# **North Byron Parklands**

## **Response to Submissions**

**MP09\_0028 Modification 3 – Lodged May 2015**

**October 2015**

Figure 2.2: Proposed noise limit zones and maximum measured  $L_{eq,oct(63Hz)}$ , SITG 2015 (dB)

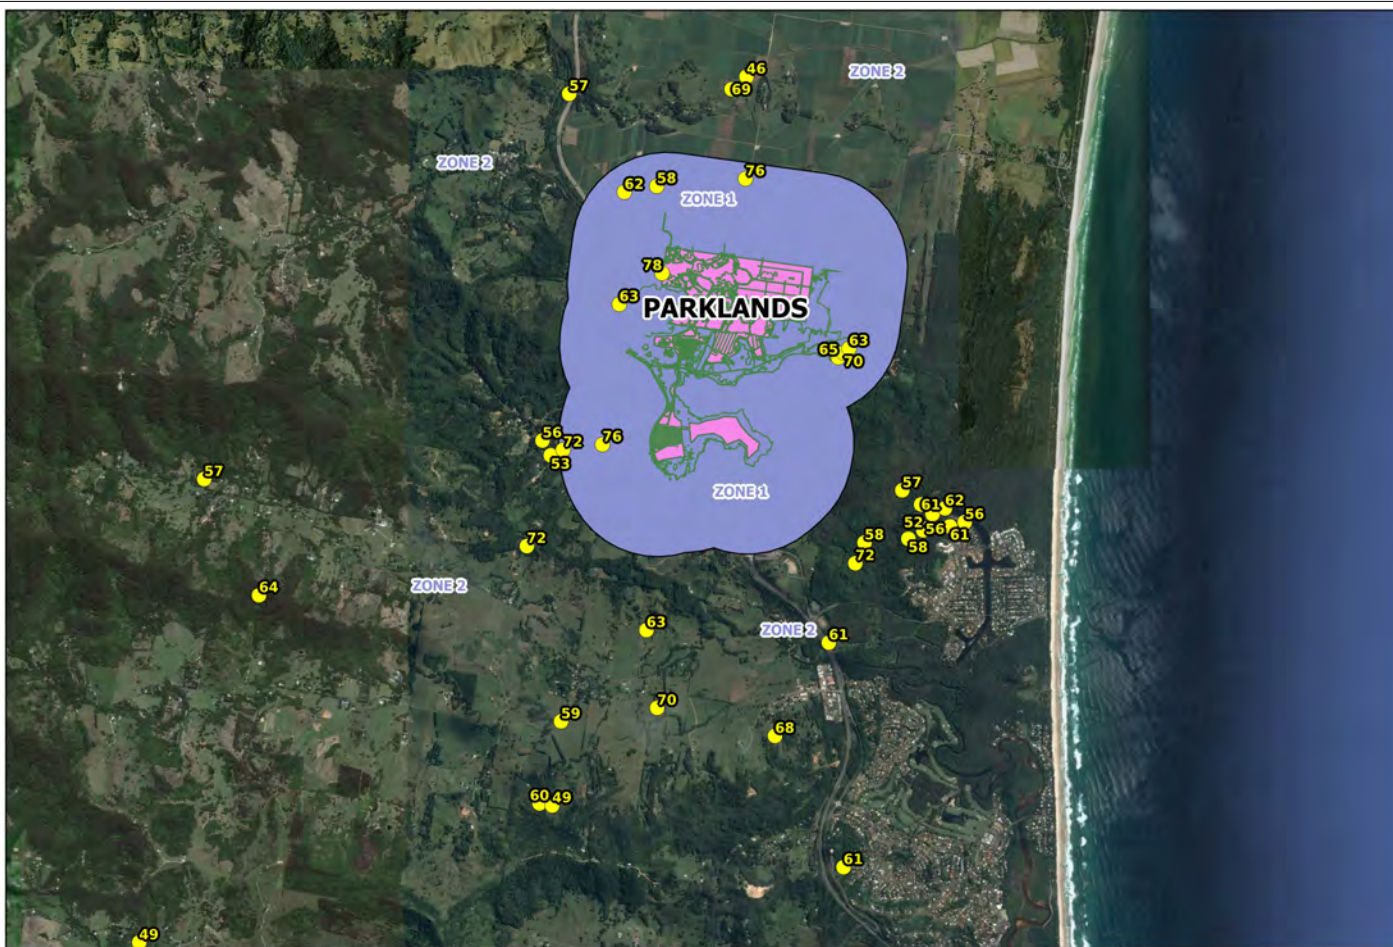
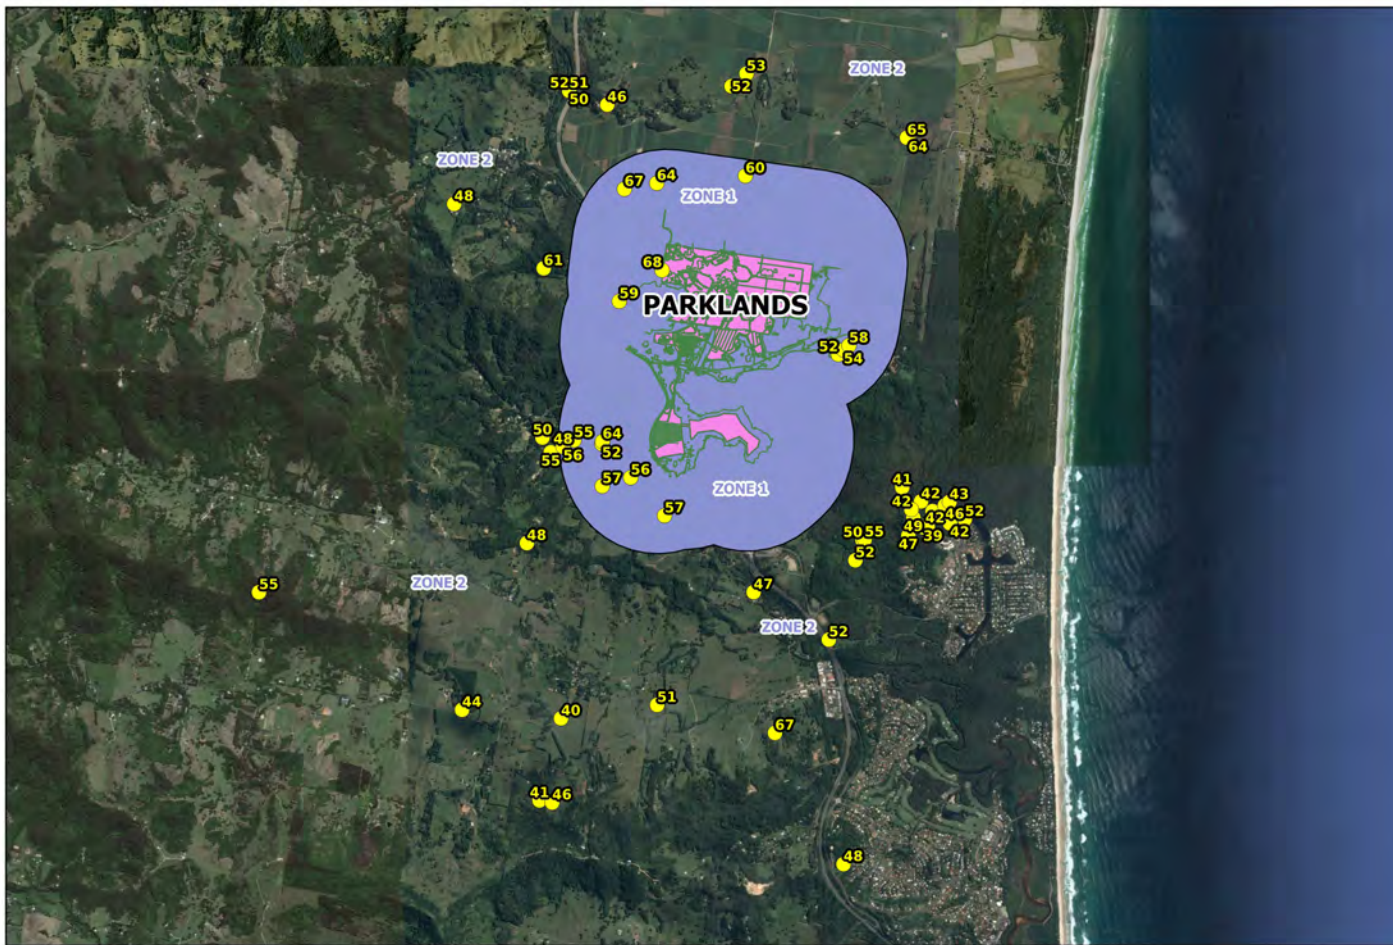
Aspect	Parklands Response
<p>Noise - The Department recommends reviewing the requested noise limits and providing 'zones' for varied noise levels</p>	<p>Agreed – Parklands now proposes revised noise criteria based on a zonal arrangement as follows:</p> <p><b>Inner Zone</b></p> <ul style="list-style-type: none"> <li>• Between 11am and midnight amplified entertainment noise from the event at sensitive receivers must not exceed 65dB(A) LAeq, 10-minutes or 75dB (lin) measured as Leq, 10-minutes in the 63 hertz 1/1 octave band; and</li> <li>• Between midnight and 2am amplified entertainment noise from the event at sensitive receivers must not exceed 55dB(A) LAeq, 10-minutes or 70dB (lin) measured as Leq, 10-minutes in the 63 hertz 1/1 octave band.</li> </ul> <p><b>Outer Zone</b></p> <ul style="list-style-type: none"> <li>• Between 11am and midnight amplified entertainment noise from the event at sensitive receivers must not exceed 60dB(A) LAeq, 10-minutes or 70dB (lin) measured as Leq, 10-minutes in the 63 hertz 1/1 octave band; and</li> <li>• Between midnight and 2am amplified entertainment noise from the event at sensitive receivers must not exceed 50dB(A) LAeq, 10-minutes or 65dB (lin) measured as Leq, 10-minutes in the 63 hertz 1/1 octave band.</li> </ul>

Aspect	Parklands Response
	<p>For the outer zone these newly proposed noise criteria would result in the following reduction in noise limits versus the blanket limits requested in the modification as submitted:</p> <ul style="list-style-type: none"> <li>• 11am to midnight <ul style="list-style-type: none"> <li>○ A-weighted – 65dB(A) <b>down to 60dB(A)</b>; and</li> <li>○ C-weighted – 75dB(C) <b>down to 70dB(C)</b>.</li> </ul> </li> <li>• Midnight to 2am <ul style="list-style-type: none"> <li>○ A-weighted – 55dB(A) <b>down to 50dB(A)</b>; and</li> <li>○ C-weighted – 70dB(C) <b>down to 65dB(C)</b>.</li> </ul> </li> </ul>
<p>Noise – Please provide further justification for the dB(C) limits proposed using data collected from previous events (i.e. complaints data where bass was specified, monitoring results at residences, etc.)</p>	<p>During the SITG15 event the number of acoustic engineers per event day/night shift were increased from 3 to 5 engineers to capture a greater number of noise level samples. Increasing the number of acoustic engineers allowed the event to not only capture data associated with calls to the community hotline, it also provided a significant number of additional noise samples to be collected during the event. In total there were 296 attended noise samples taken across the event period at varying locations and during varying meteorological conditions (refer Appendix D). In particular, these attended noise samples captured lower frequency data (C-weighted).</p> <p>What this additional low frequency data from the SITG15 event showed was that the proposed C-weighted noise criteria of 75dB(C) between 11am and midnight and 70dB(C) between midnight and 2am was potentially too intrusive for some receptors, particularly in higher density residential areas. As discussed above, it is now proposed to implement a zonal arrangement (inner and outer zones) with differing noise criteria that will improve the amenity of community members. In particular, reductions in bass frequency noise criteria have been made. For the outer zone the following noise criteria reductions are proposed:</p> <ul style="list-style-type: none"> <li>• 11am to midnight <ul style="list-style-type: none"> <li>○ A-weighted – 65dB(A) down to 60dB(A); and</li> <li>○ C-weighted – 75dB(C) down to 70dB(C).</li> </ul> </li> </ul>

Aspect	Parklands Response
	<ul style="list-style-type: none"> <li>• Midnight to 2am               <ul style="list-style-type: none"> <li>○ A-weighted – 55dB(A) down to 50dB(A); and</li> <li>○ C-weighted – 70dB(C) down to 65dB(C).</li> </ul> </li> </ul>
Adjust the units of the dB(C) limits to align with proposed practice in the AMP for Splendour in the Grass 2015 (i.e. Leq, 63Hz).	Agreed. The consent mark-up in <b>Appendix A</b> has been amended to reflect this change.
Noise – Please provide justification as to how the limits proposed would '... <i>deliver greater amenity to the surrounding community</i>	<p>Based on the significant number of additional noise samples collected during the SITG15 event further analysis was undertaken to determine the appropriateness of the proposed noise criteria, particularly the lower end or bass frequencies.</p> <p>What this additional low frequency data from the SITG15 event showed was that the proposed C-weighted noise criteria of 75dB(C) between 11am and midnight and 70dB(C) between midnight and 2am was potentially too intrusive for some receptors, particularly in higher density residential areas. As discussed above, it is now proposed to implement a zonal arrangement (inner and outer zones) with differing noise criteria that will improve the amenity of community members.</p> <p>For the outer zone the following noise criteria reductions are proposed:</p> <ul style="list-style-type: none"> <li>• 11am to midnight               <ul style="list-style-type: none"> <li>○ A-weighted – 65dB(A) down to 60dB(A); and</li> <li>○ C-weighted – 75dB(C) down to 70dB(C).</li> </ul> </li> <li>• Midnight to 2am               <ul style="list-style-type: none"> <li>○ A-weighted – 55dB(A) down to 50dB(A); and</li> <li>○ C-weighted – 70dB(C) down to 65dB(C).</li> </ul> </li> </ul>
